**A66 Northern Trans-Pennine Project
TR010062**

6.1 Errata Report (Rev 3)

**6.1 DEVELOPMENT CONSENT ORDER ERRATA REPORT
(REV 3)**

Planning Inspectorate Scheme Reference	TR010062
Application Document Reference	6.1
Author:	A66 Northern Trans-Pennine Project Team, National Highways

Drawing Title: Classification of Roads Plan  
 Regulation 5(2)(o)  
 Sheet 2 of 2

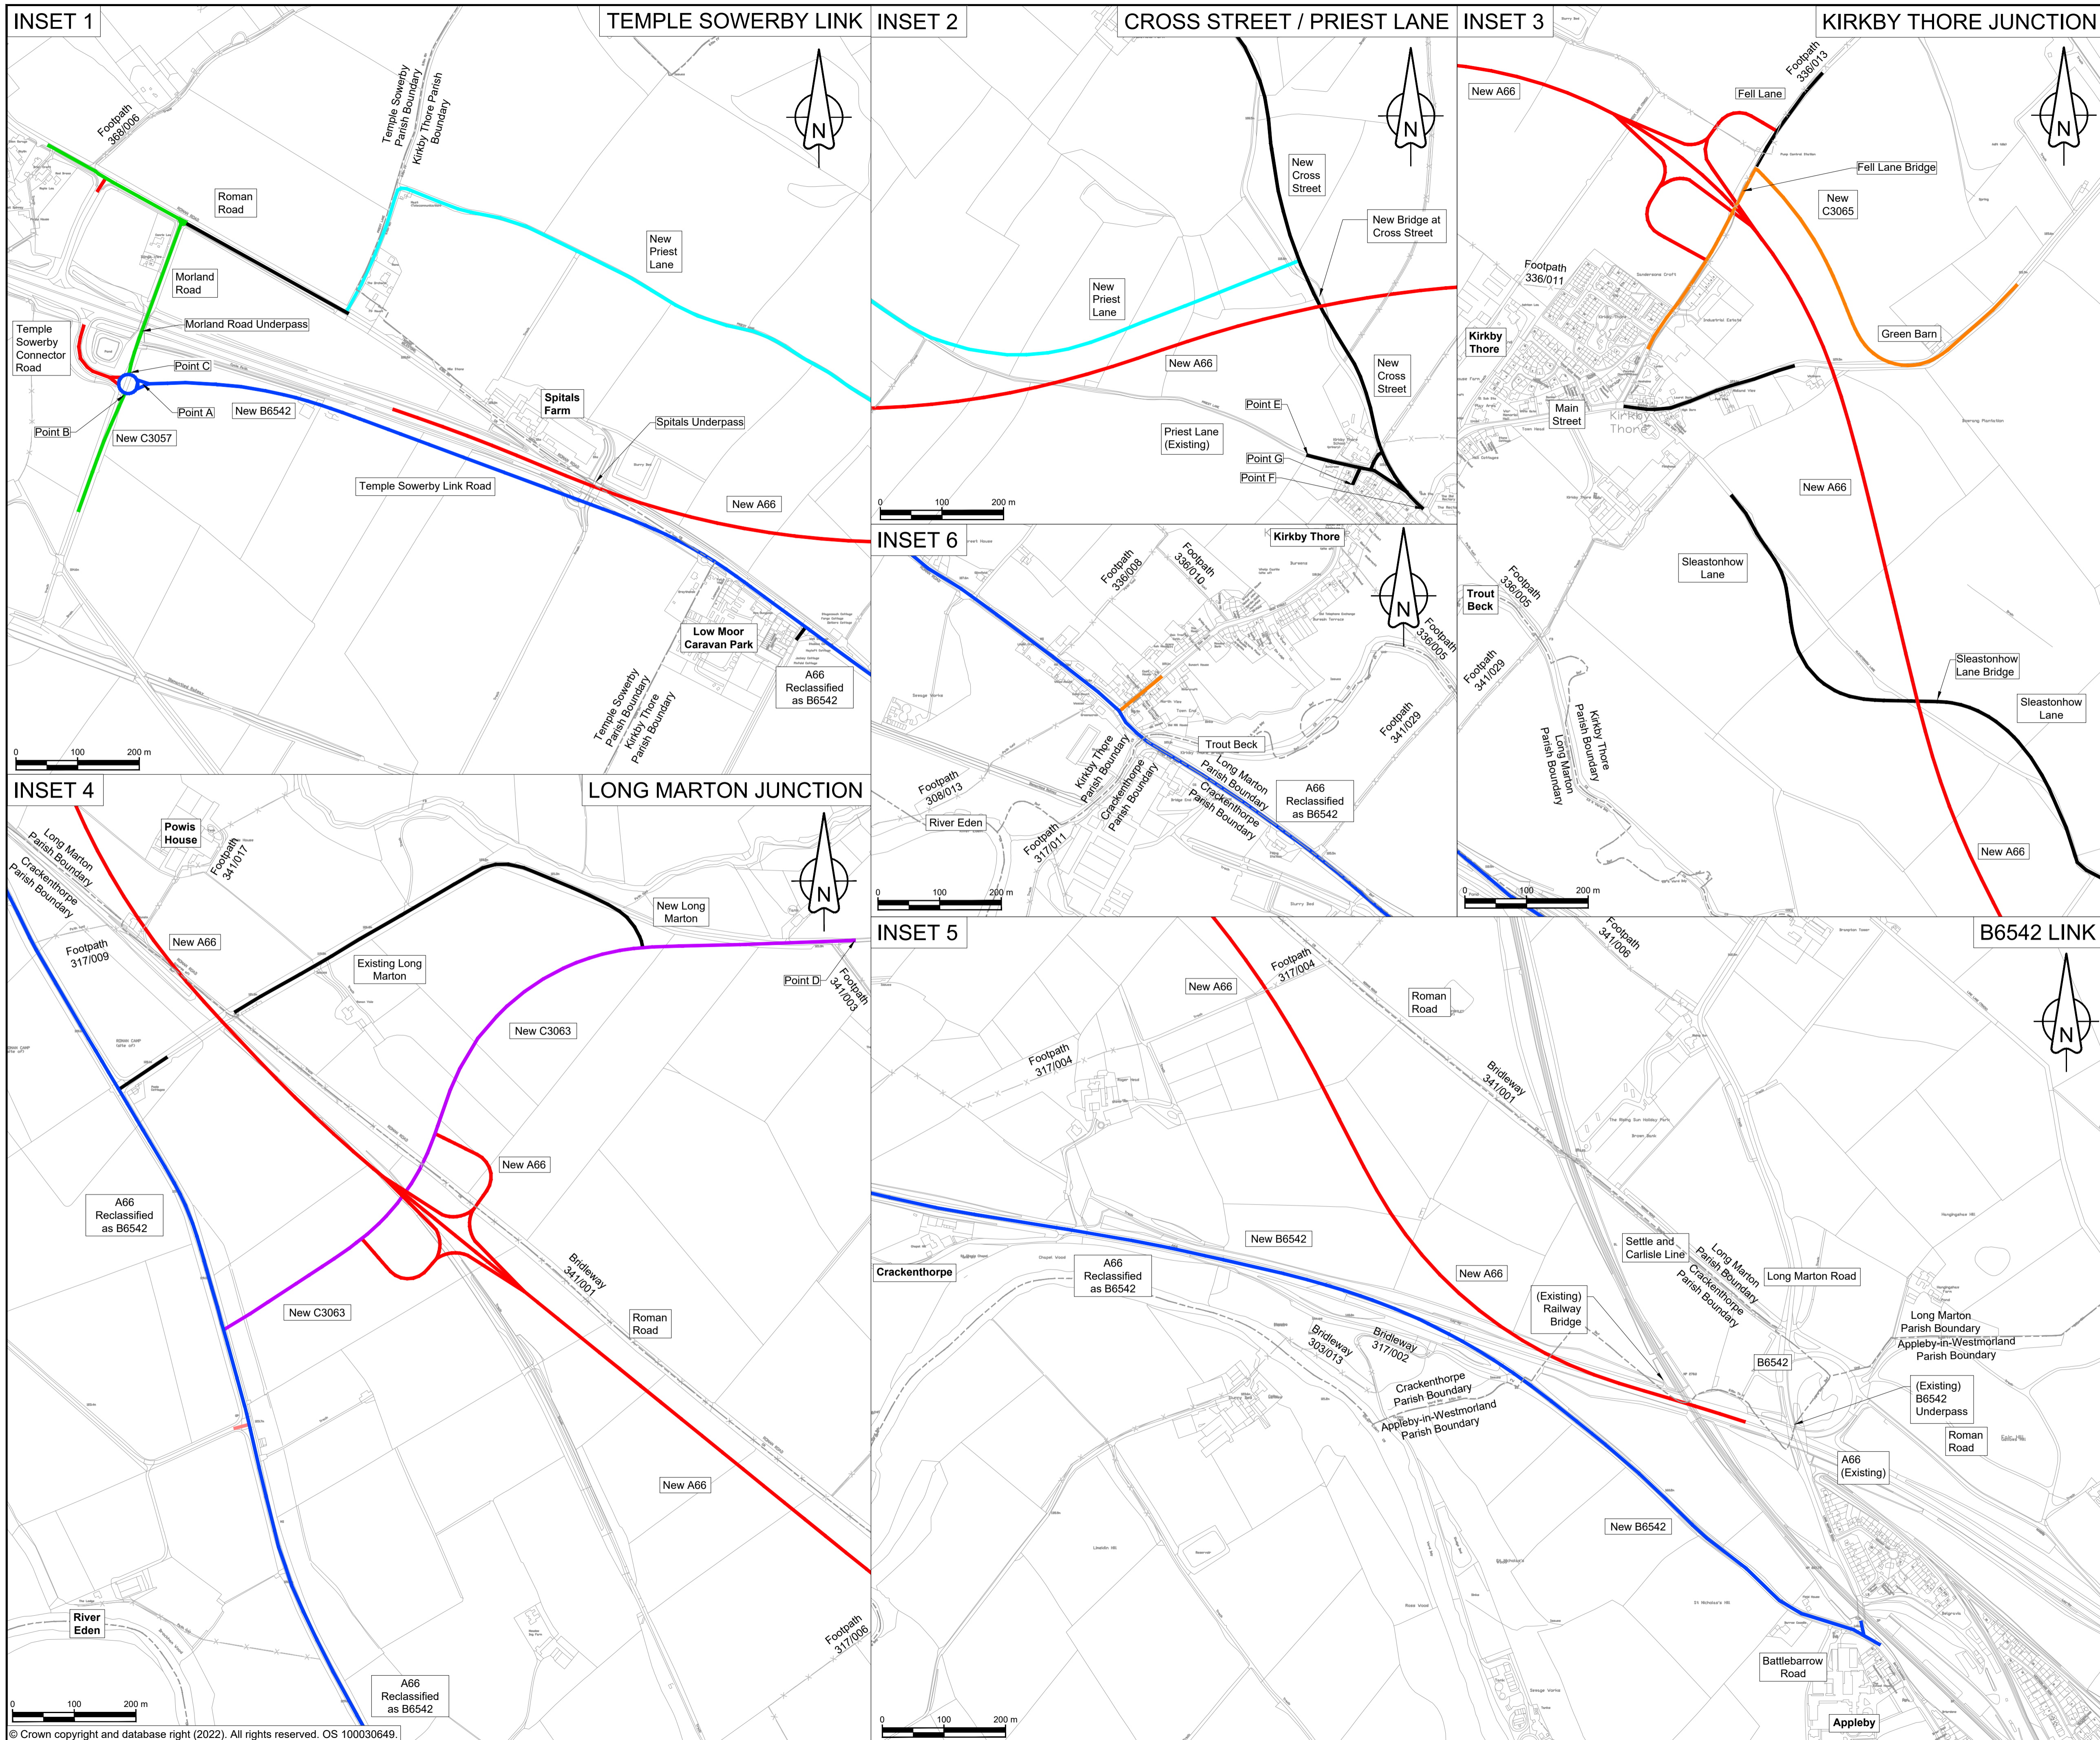
Sheet 2 of 2	Naming of roads	Following agreement with Westmorland and Furness Council the following amends have been made: <ul style="list-style-type: none"> B1066 replaced with C3077 in both plan (Insets 2, 3 and 4) and legend; Unclassified Road numbers removed (Inset 2); and Moorhouse Link annotated as a result of accepted change DC-19 (Inset 2 and 4); and Label for 'Langrigg Westbound Junction' amended to read 'New Langrigg Link Junction' (as a result of accepted change DC-25). 									
REP7-003 - 2.5 (Rev 2) General Arrangement Drawings Scheme 06 Appleby to Brough	Sheet 3 of 6	Change to hatching in drawing	A short section length of shared cycleway had been incorrectly hatched and was not clear on omitted from a localised area on Sheet 3 of the General Arrangement drawings . Drawing has been updated to show this connection include the missing length so that the drawing aligns correctly with the cycleway provision in the DCO (as provided for in Schedule 2 to the DCO and shown on the corresponding Rights of Way and Access Plans) description .							Updated to 2.5 (Rev 3) and issued at Deadline 8

Drawing Title
**Special Category Land Plans
Regulation 5(2)(i)
Sheet 1 of 2**

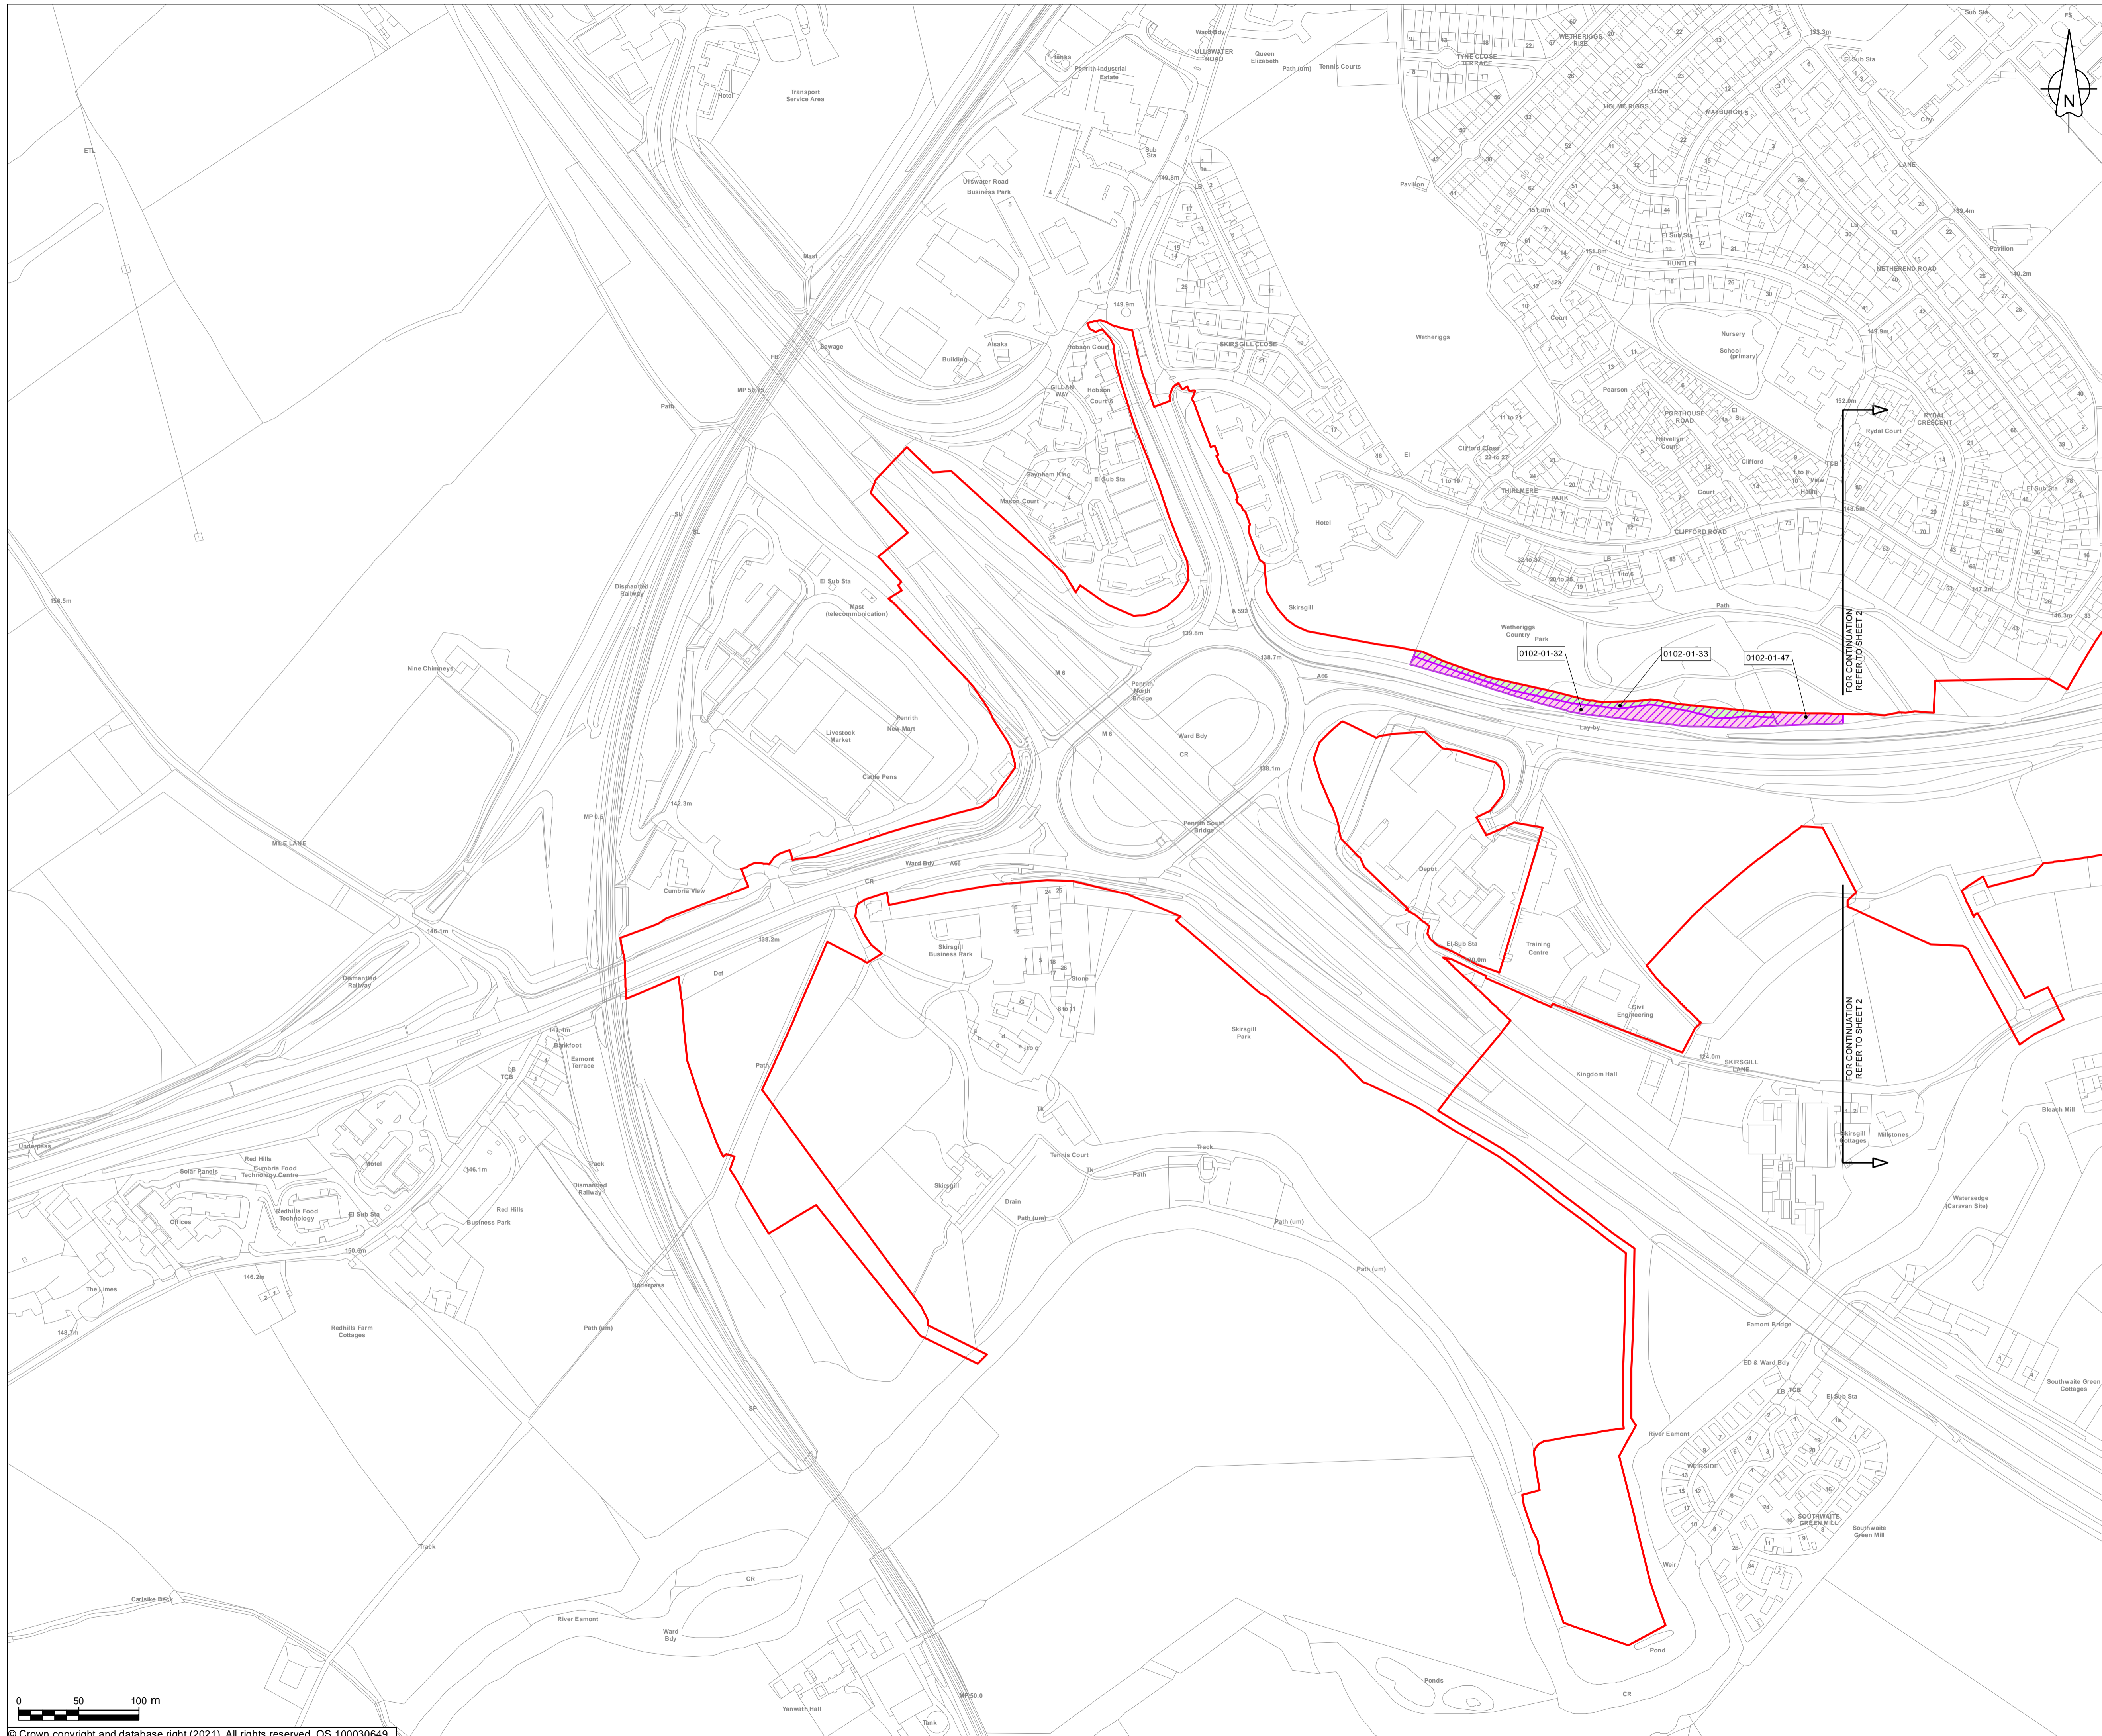
Application Document Reference	Section and Paragraph Reference	Nature of Erratum and Explanation	Amendment / Replacement Text	Update																																				
APP-287 5.4 Consents and Agreements Position Statement	Paragraph 3.2.3	Incorrect local authority reference.	These have been progressed by the Applicant working with the following stakeholders and as follows: <ul style="list-style-type: none"> Defence Infrastructure Organisation (Ministry of Defence) Cumbria County Council and Eden District Council Durham County Council North Yorkshire County Council and Richborough Borough Richmondshire District Council Representatives of the Travellers Community Natural England Environment Agency Historic England AONB Partnership 	Richmondshire District Council was dissolved on 1 April 2023 and is now taken over by North Yorkshire Council. The Consents and Agreements Position Statement has not been updated.																																				
APP-299 5.8 Statement of Reasons	Paragraph 2.1.9	Amendment to provide clarity regarding M6 Junction 40 and Kemplay Bank Roundabout.	The M6 Junction 40 to Kemplay Bank scheme would provide a three-lane circulatory carriageway with spiral markings, within the footprint of the current roundabout at M6 Junction 40. The A66 eastern arm of the roundabout would be widened to three lanes in each direction between M6 Junction 40 and Kemplay Bank Roundabout to increase capacity for local movements around Penrith. Widening would be required on the following five approach arms to M6 Junction 40 to provide additional lanes and a dedicated left turn facility, each controlled under its own signal phase : M6 North, M6 South, A66 East, A66 West, and A592 Ullswater Road.	This was amended in 5.8 Statement of Reasons, Rev 2 (REP2-012) which was submitted at Deadline 2)).																																				
APP-299 5.8 Statement of Reasons	Paragraph 2.1.17	Clarification on the police observation points	A police observation point would be included on The verges on the Kemplay Bank overbridges are an appropriate width for use as a police observation point for intermittent mobile speed enforcement purposes.	This was amended in 5.8 Statement of Reasons, Rev 2 (REP2-012) which was submitted at Deadline 2)).																																				
APP-299 5.8 Statement of Reasons	Paragraph 2.1.69	Incorrect number of ponds referenced.	18-20 ponds are proposed at low points in the scheme to attenuate drainage and run-off from the road in order to manage the water quality before it is discharged into the surrounding watercourses. Shared and dedicated access tracks are proposed to be provided to the north and to the south of the road to facilitate access to ponds for maintenance purposes and to accommodate landowner movements.	This was amended in 5.8 Statement of Reasons, Rev 2 (REP2-012) which was submitted at Deadline 2)).																																				
APP-299 5.8 Statement of Reasons	Paragraph 7.2.10 – associated table	Plot 0102-02-54 was not included within the table.
